Planning Department
Alan Varela, Director

May 26, 2022

Re: Bluesky Distributing - 9401 Bluewater Rd. NW
ESC Plan Engineers Stamp Date: 4/21/2022 – K09E050

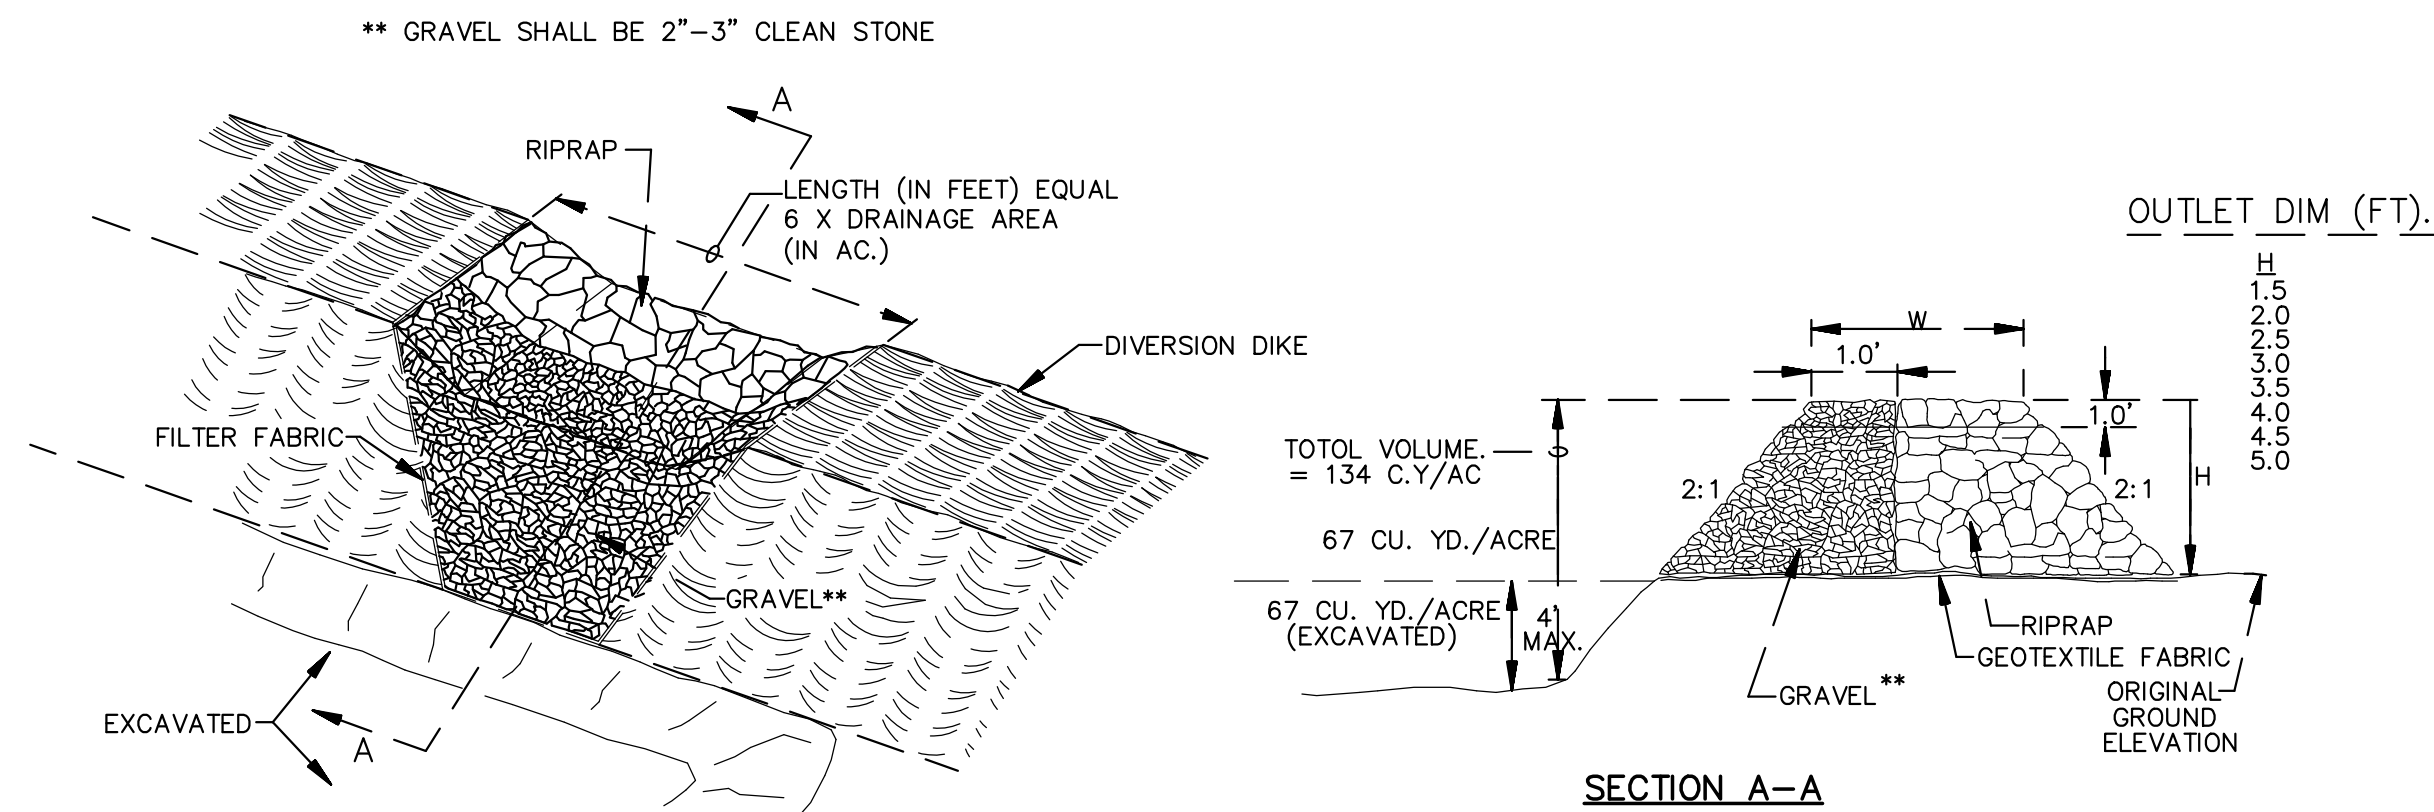
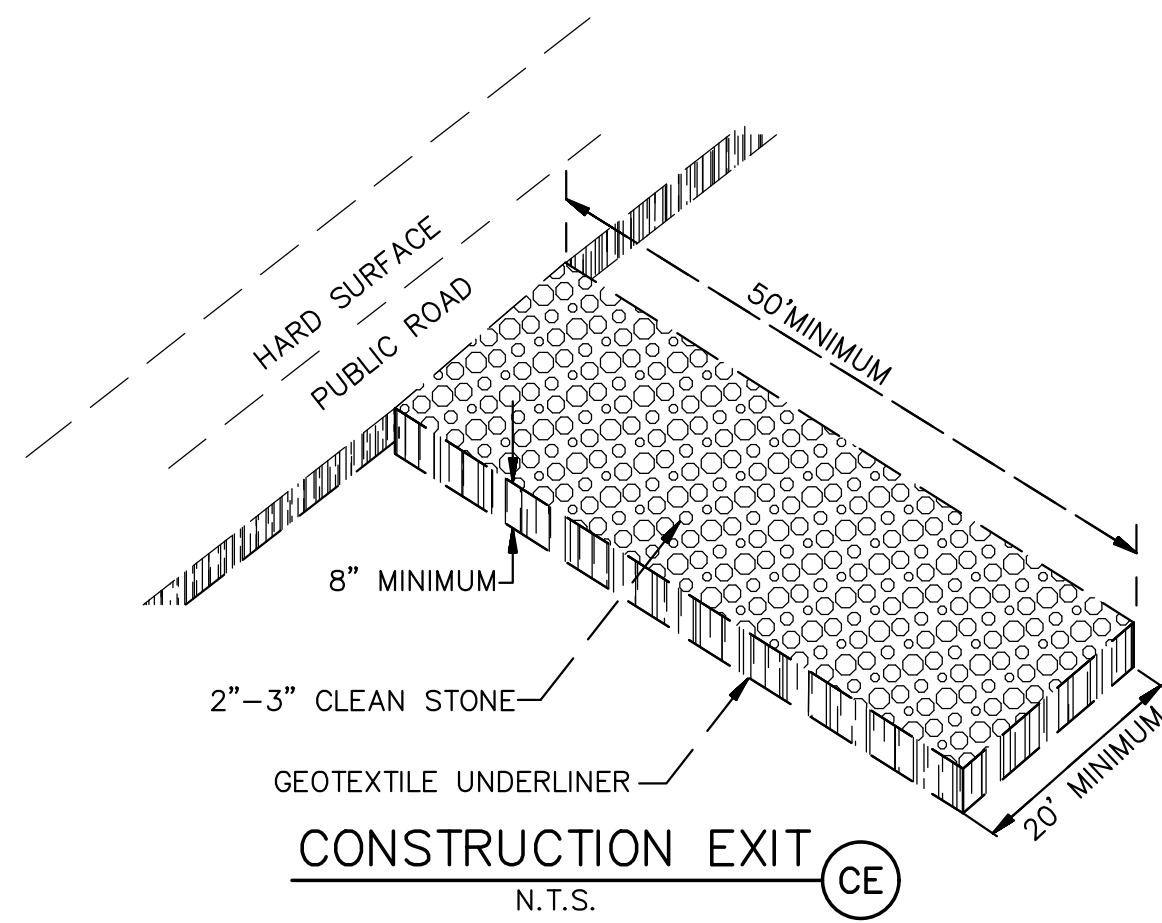
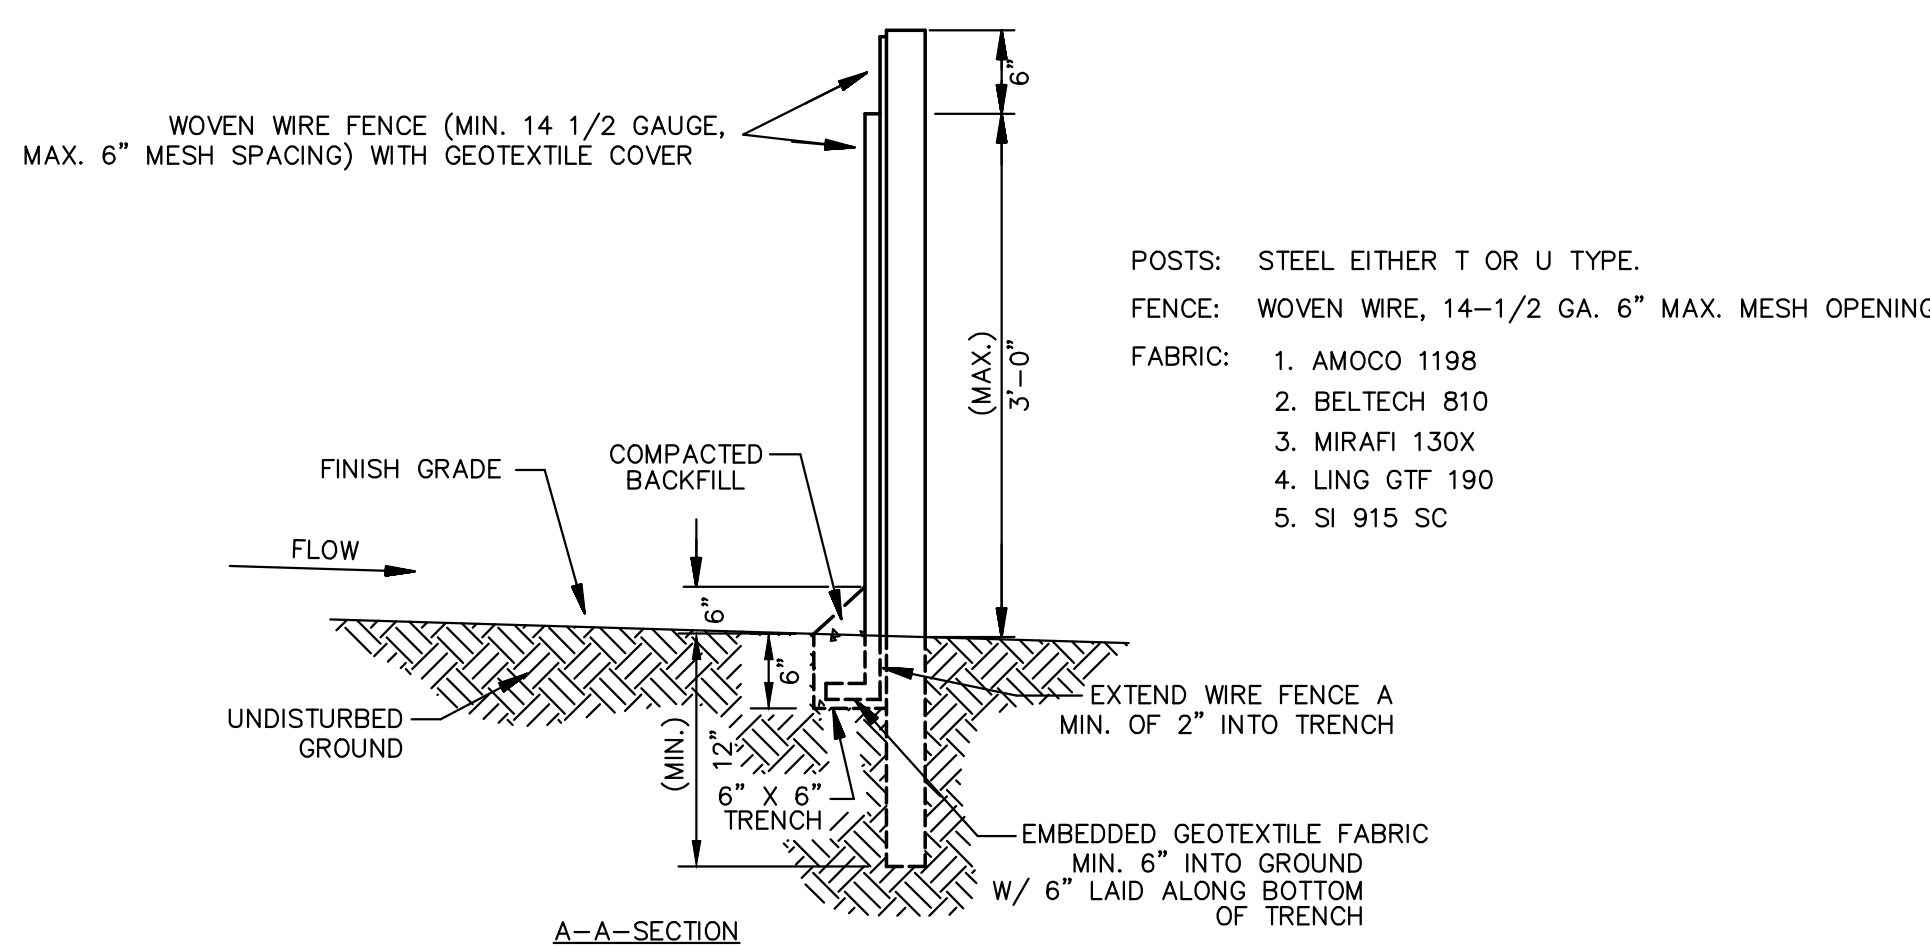
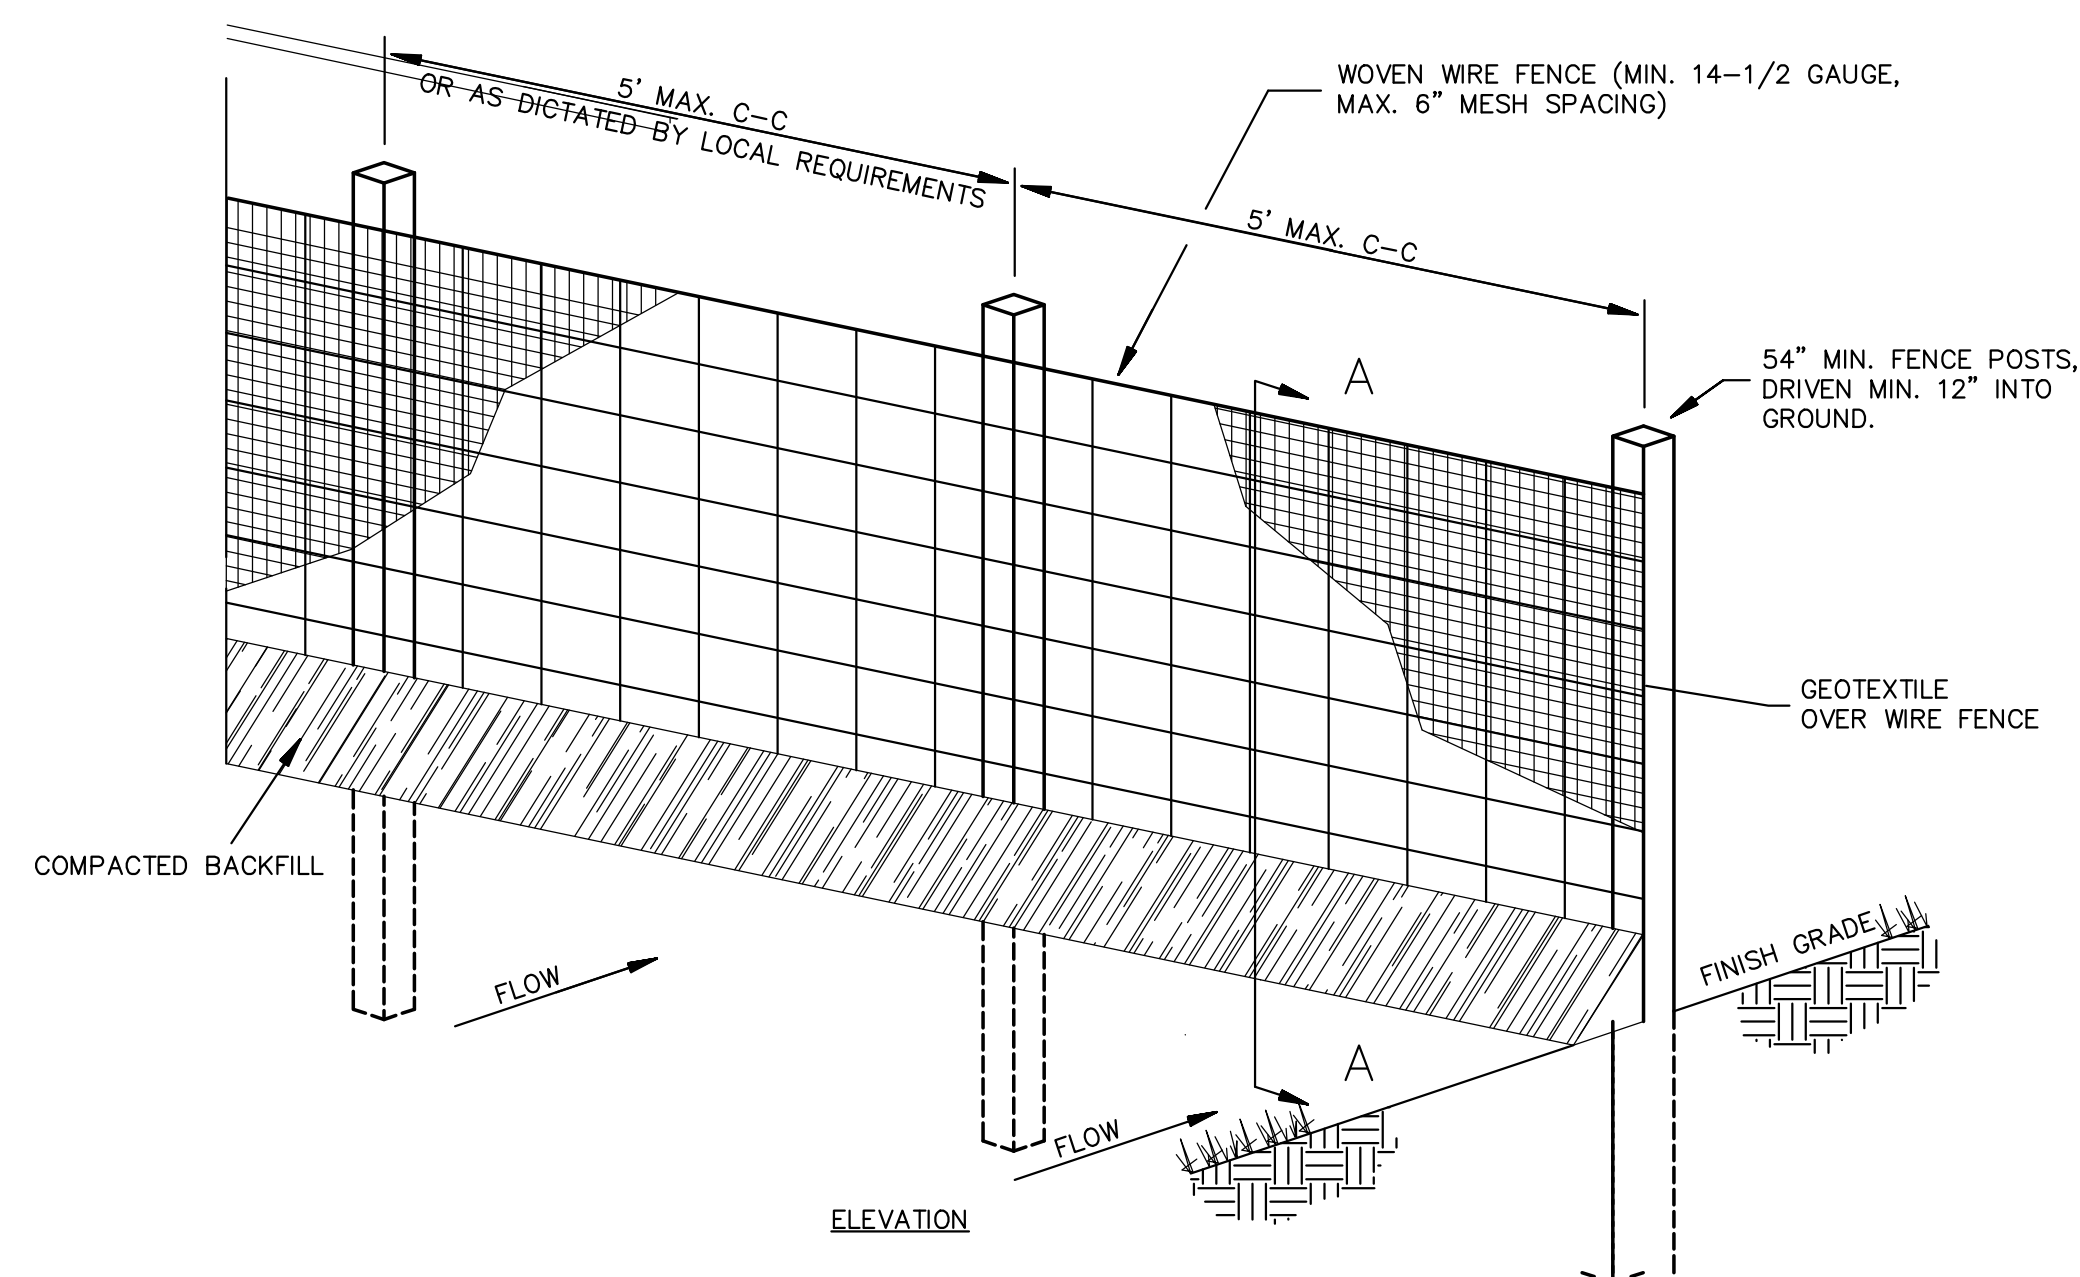
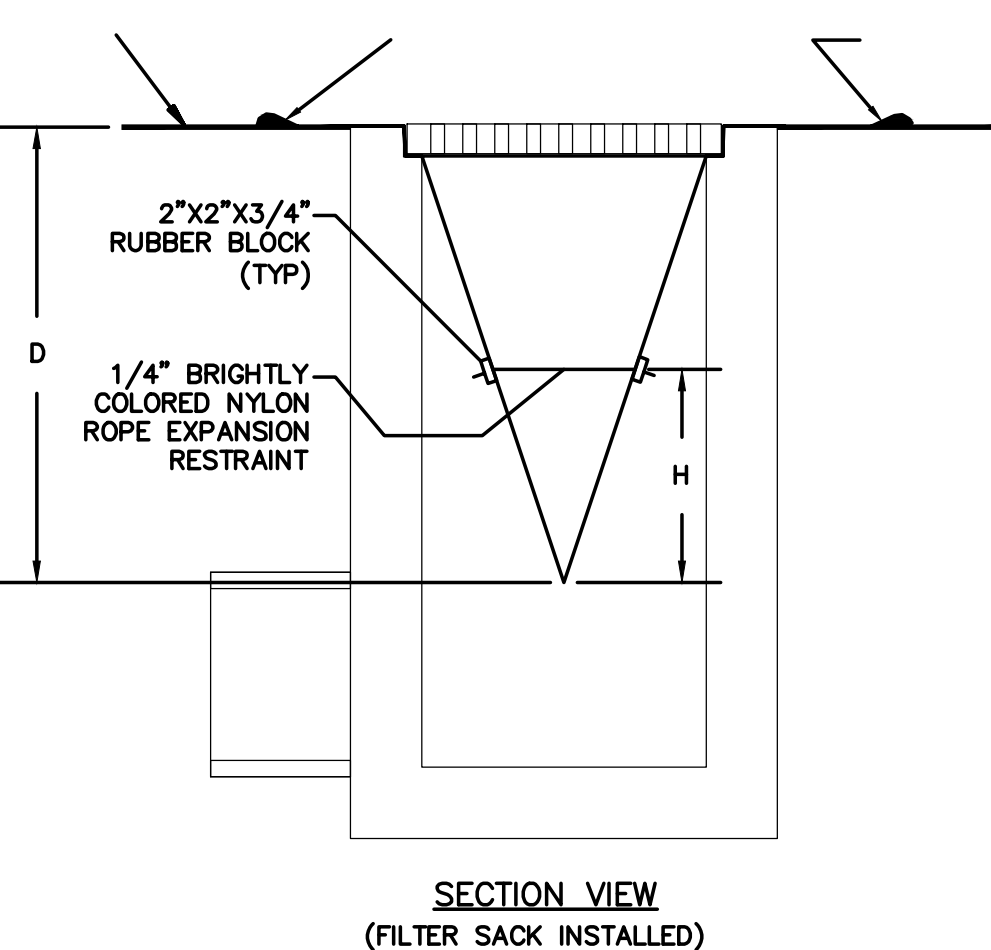
1. Aspen Autumn, LLC will be the new property owner in control of both the Work Order and the Building Permit. An NOI is required in the Property owner's name prior to approval for Building Permit or Work Order.
2. The SWPPP must include site-specific interim and permanent stabilization per CGP 9.4.1.c.i. The Landscape Plan and Work Order sheets can be used to satisfy this requirement and should be submitted separate from the ESC Plan with the application to the Stormwater Quality Section of the Planning Department and they should be included in the SWPPP.
3. Soil information – add a table with name type, particle sizes, and Erodibility factor (CGP 2.1.1).
4. The silt fence should be moved to the limits of disturbance on the south and west sides of the site to keep it out of the way of the sidewalk construction.
5. Update the engineer's stamp date each time the plan is changed.
